Rezoning Transportation Analysis

Petition Number: #2022-107

Date	Description
11-28-22	First Review (IW)
12-22-22	Second Review (DR)

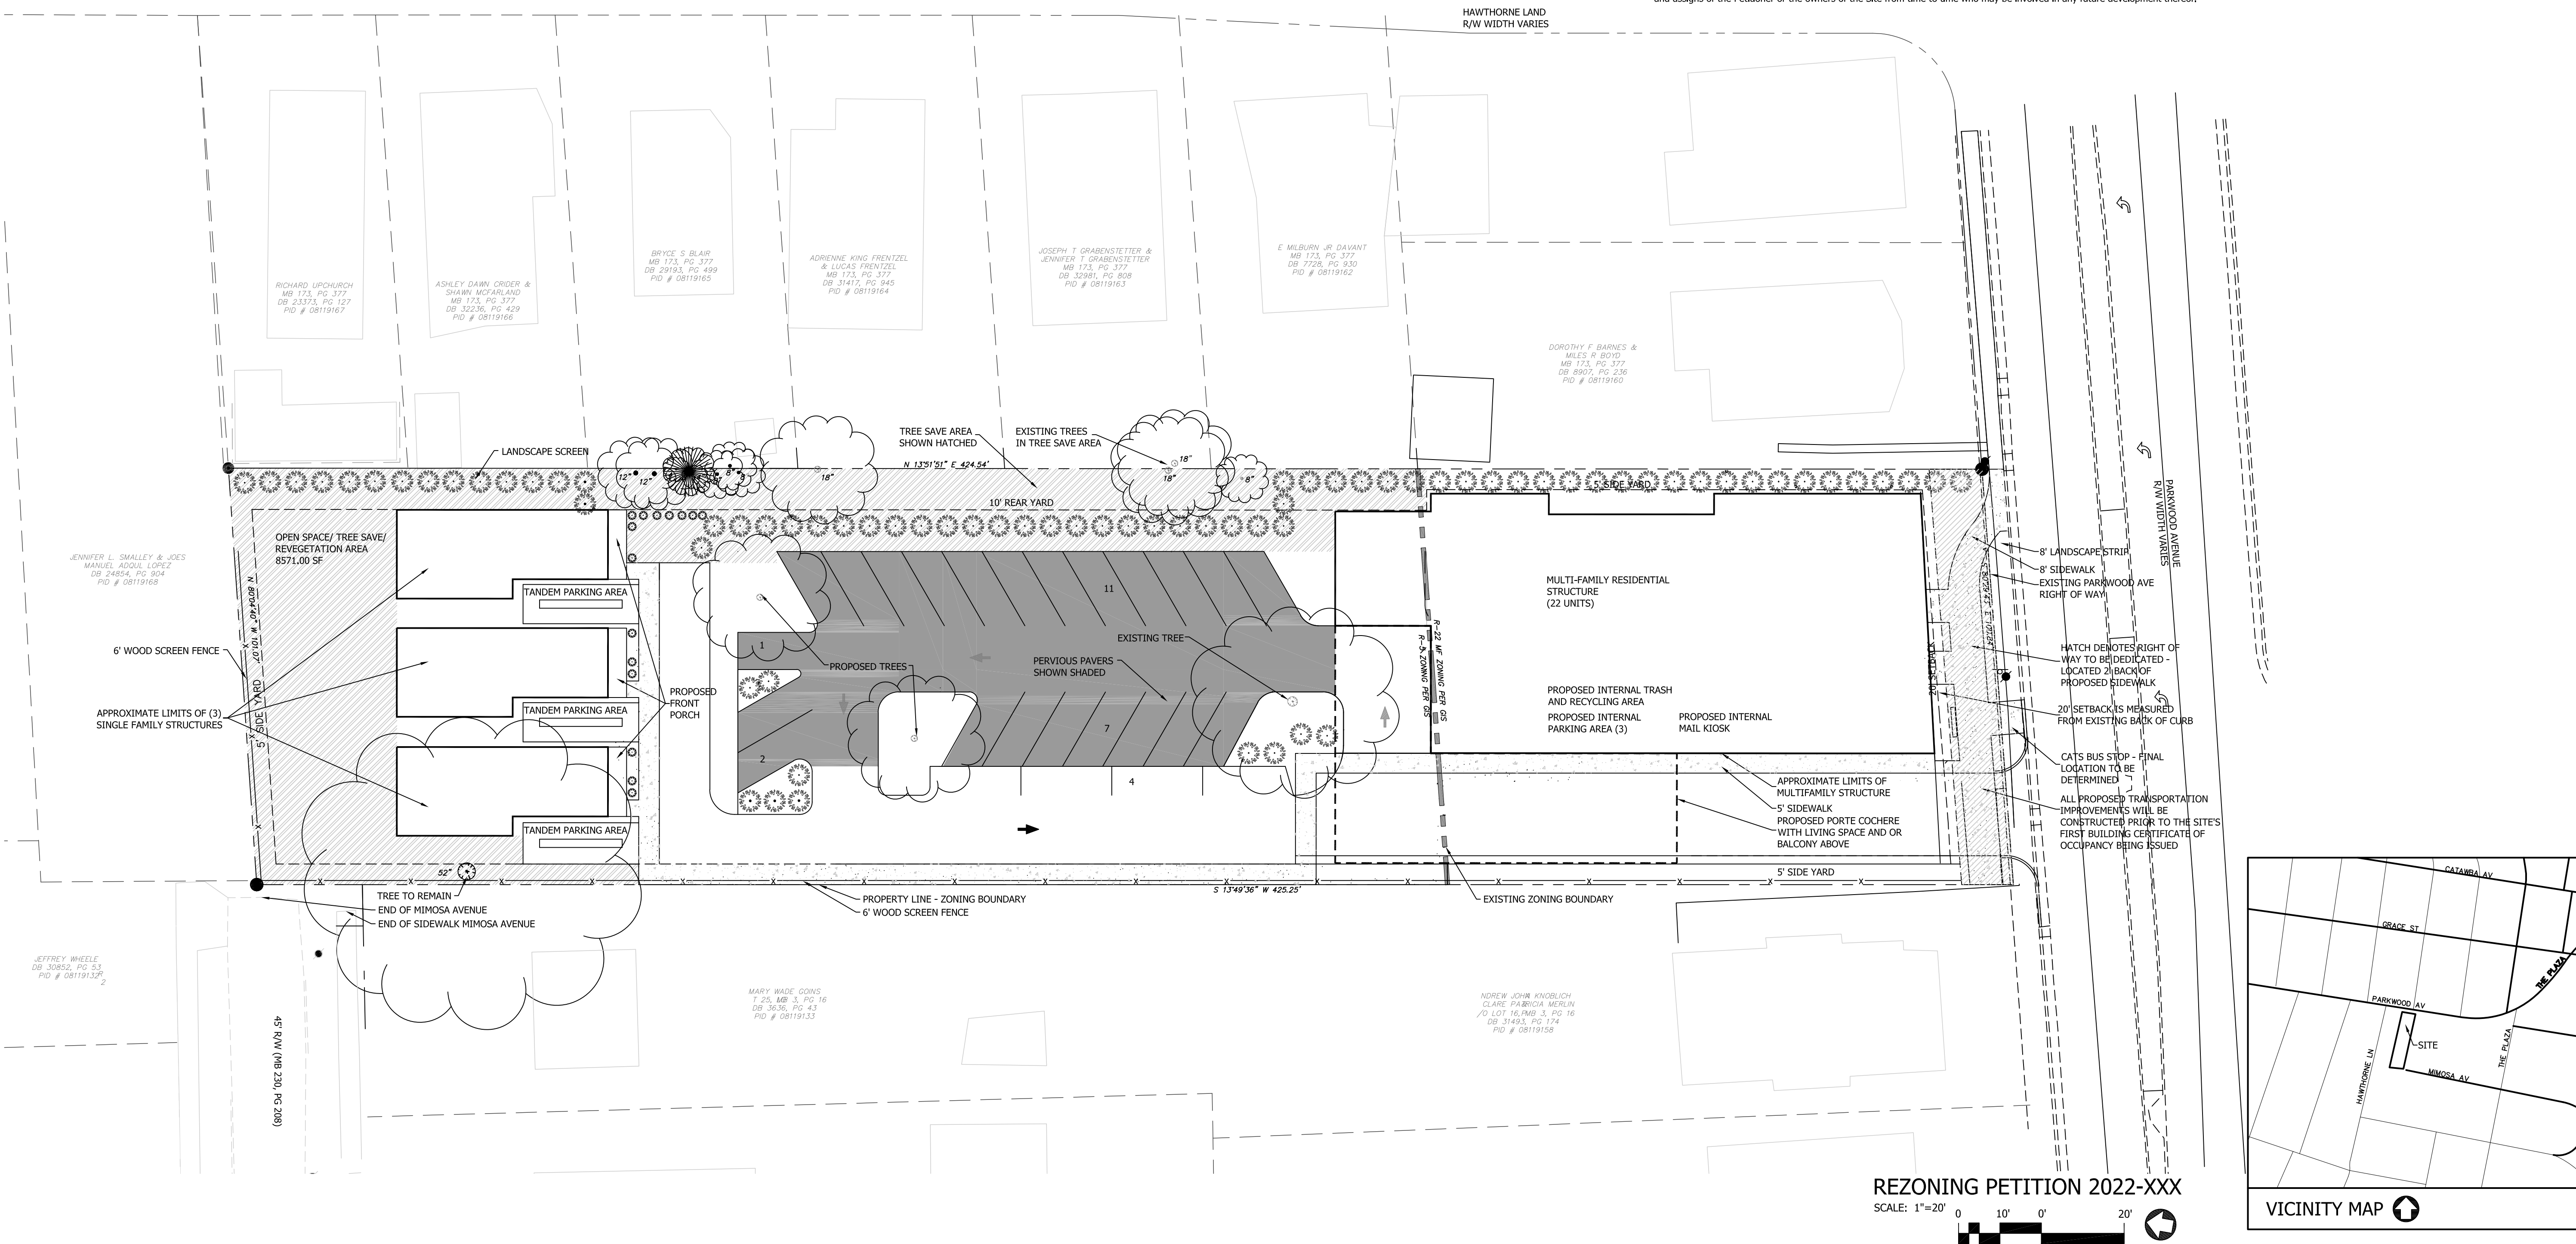
1. **Curbline:** The proposed zoning district has a setback measured from back of the existing or proposed future curbline.
 - a. **Parkwood Avenue:** Location of curb and gutter is 38 feet from centerline.

Outstanding Comment from 11-28-22 Label and dimension the curb and gutter from the centerline for each road on the site plan.

3. **Outstanding Comment from 11-28-22** Revise site plan and conditional note(s) to commit to dedicate 56 feet of right-of-way from the road centerline. The site plan shall label and dimension the right-of-way from the road centerline.
4. CDOT requests the site plan and conditional note(s) revisions are needed to commit to connect sidewalk near single family structure to existing sidewalk on Mimosa Avenue.

Clarifying comment from 12/22/2022: Commit to connect sidewalk near single family structure to existing sidewalk on Mimosa Avenue as shown above.

5. Site plan and conditional note(s) revisions are needed to commit to extending the 8' sidewalk to property line along Parkwood Avenue.

Clarifying comment from 12/22/2022: Extend 8-foot sidewalk as shown above to property line along Parkwood Avenue.
